Demolition of three buildings & erection of replacement workshop & machinery store
(amended to FG/161/14/PL).

Onslow Caravan Park Onslow Drive Ferring

Thank you for your internet representation made on 9th June 2015 which has been recorded as '**an objection**' with the comments as follows:

| Project | ADC/5/14   | Sheet | 4F |

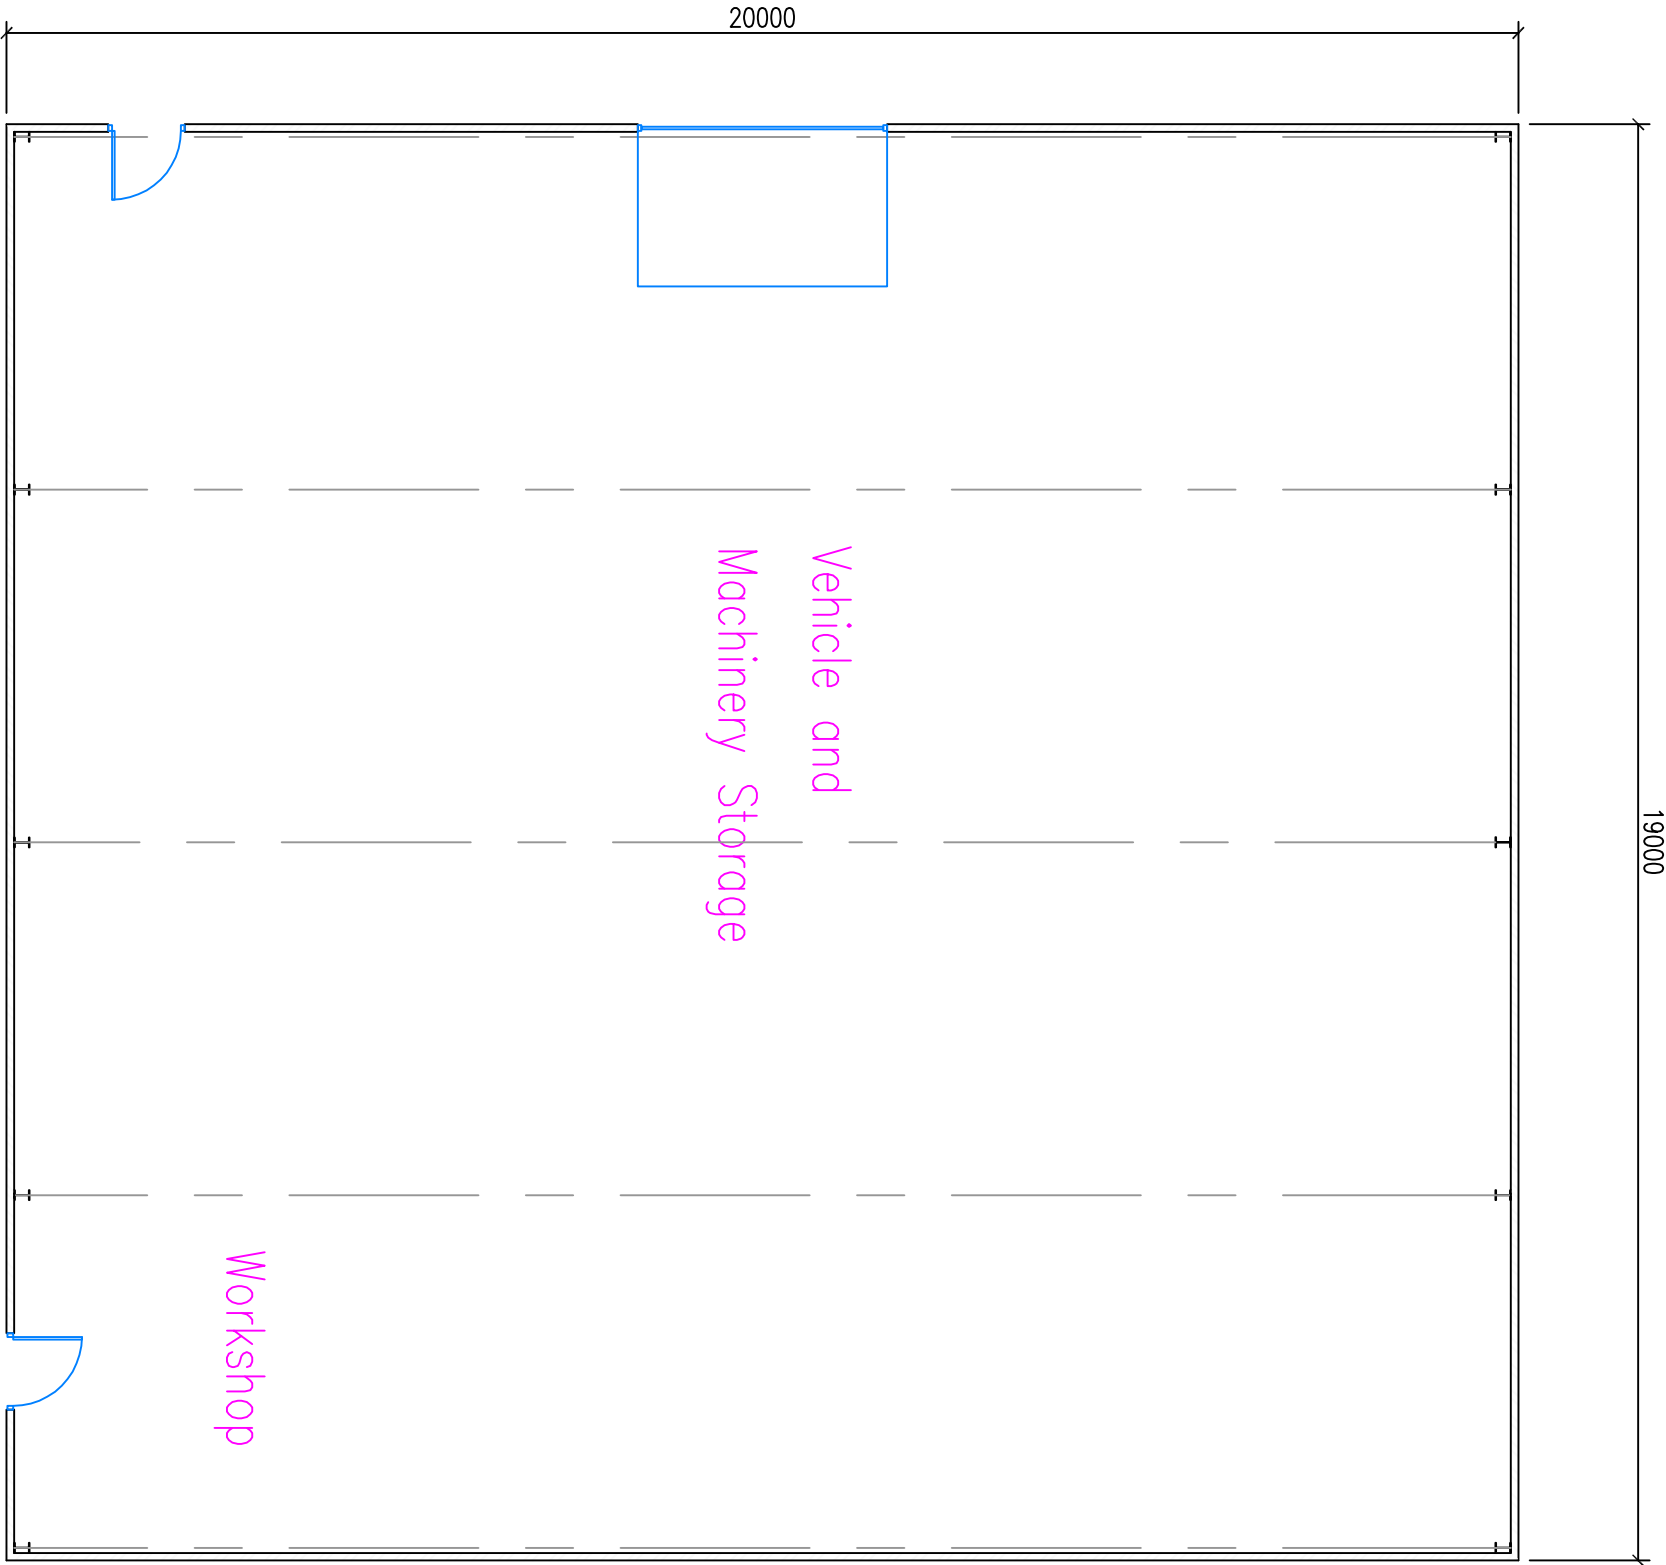
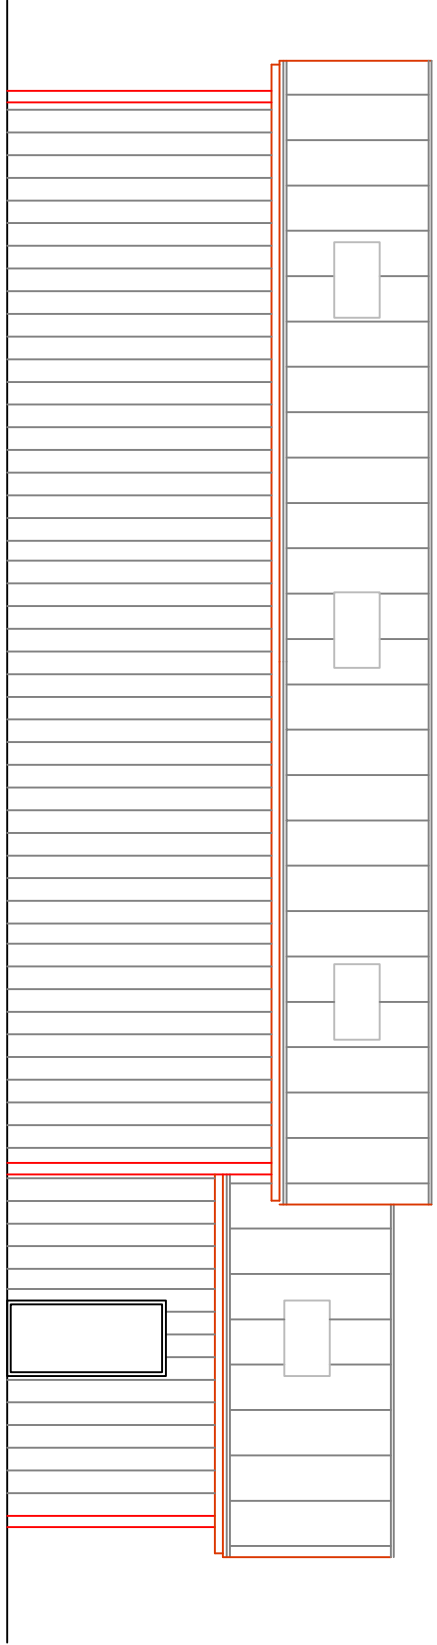
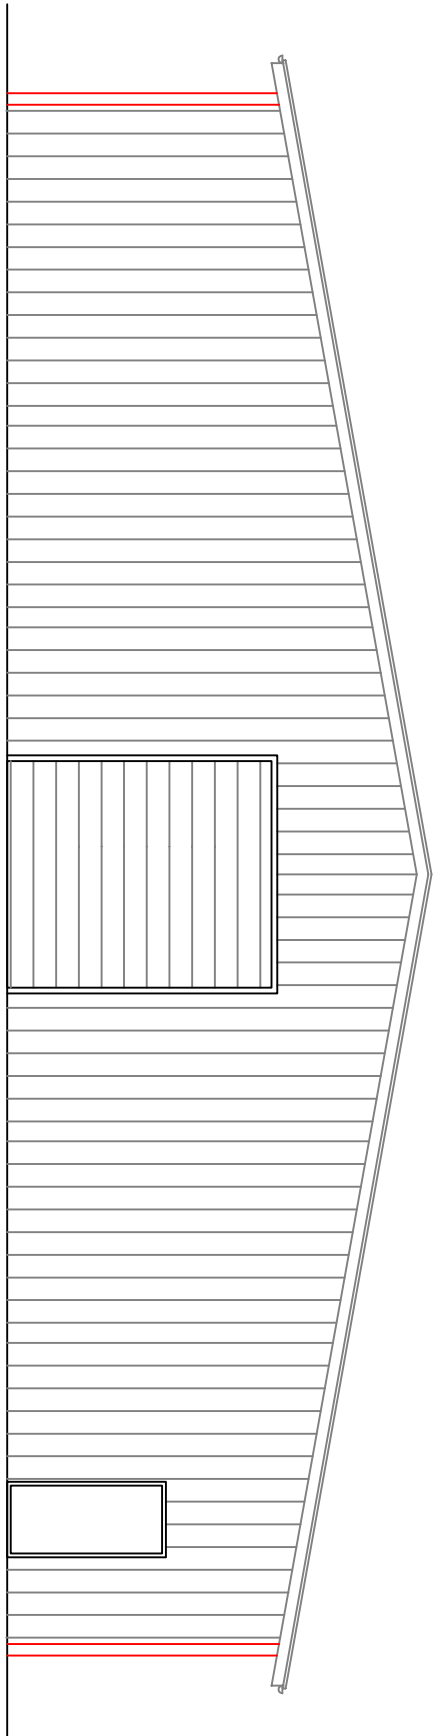
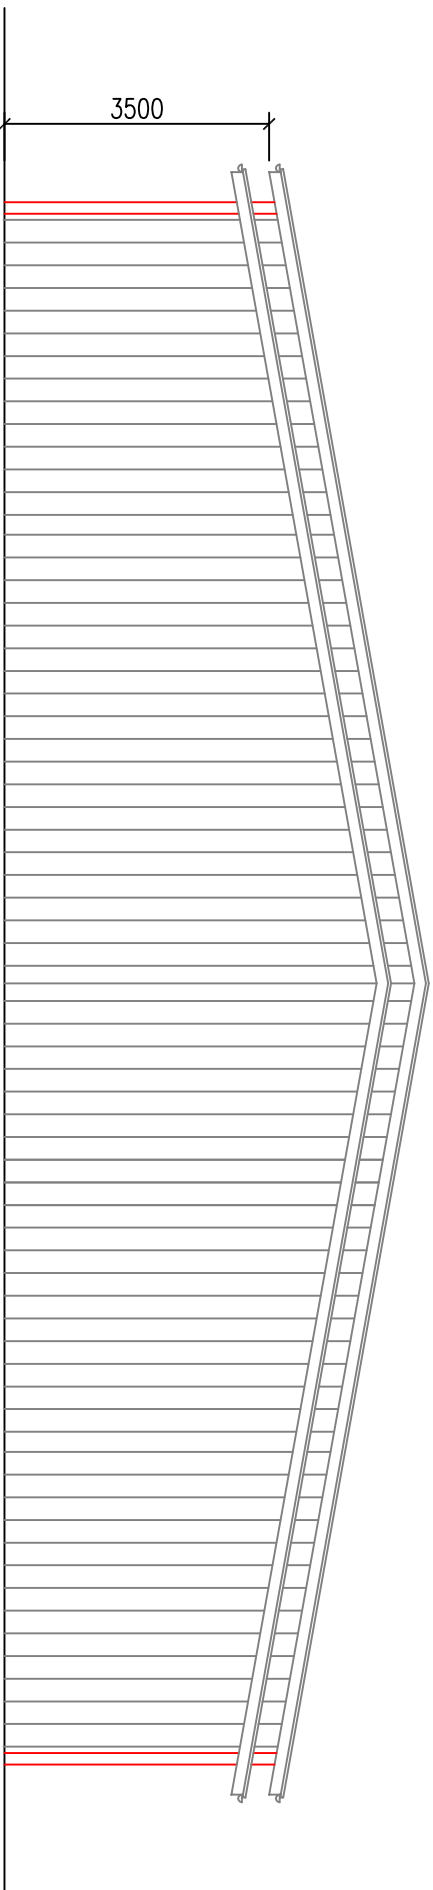
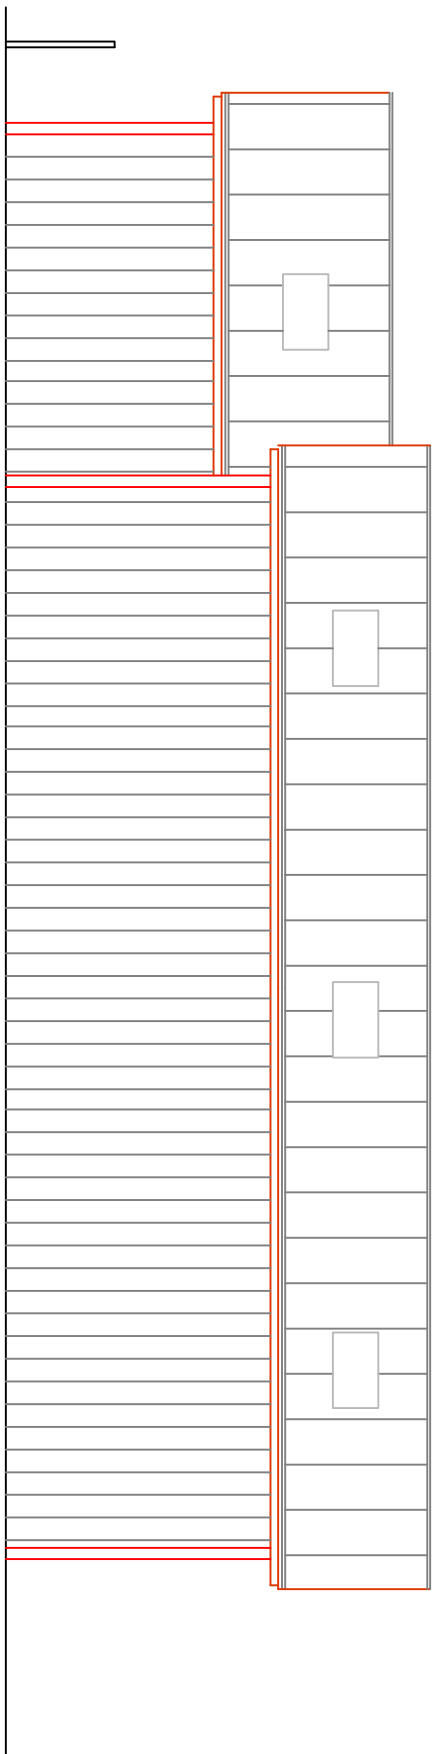
we are writing to you to object to the proposed workshop location, it would be sited right in front of 12 holiday homes, visible to many more and will look completely out of place due to its significant size and location also taking up the 1st green open space inside the site which is used by children to play on.

The application states that it will be used for the storage of hand held machinery we do not consider a dumper truck, land rover, plant trailer, ride on mower and a JCB type digger to be hand held machinery.

At the rear of the site there is a very large field which would be a much more suitable location for the building of this size.
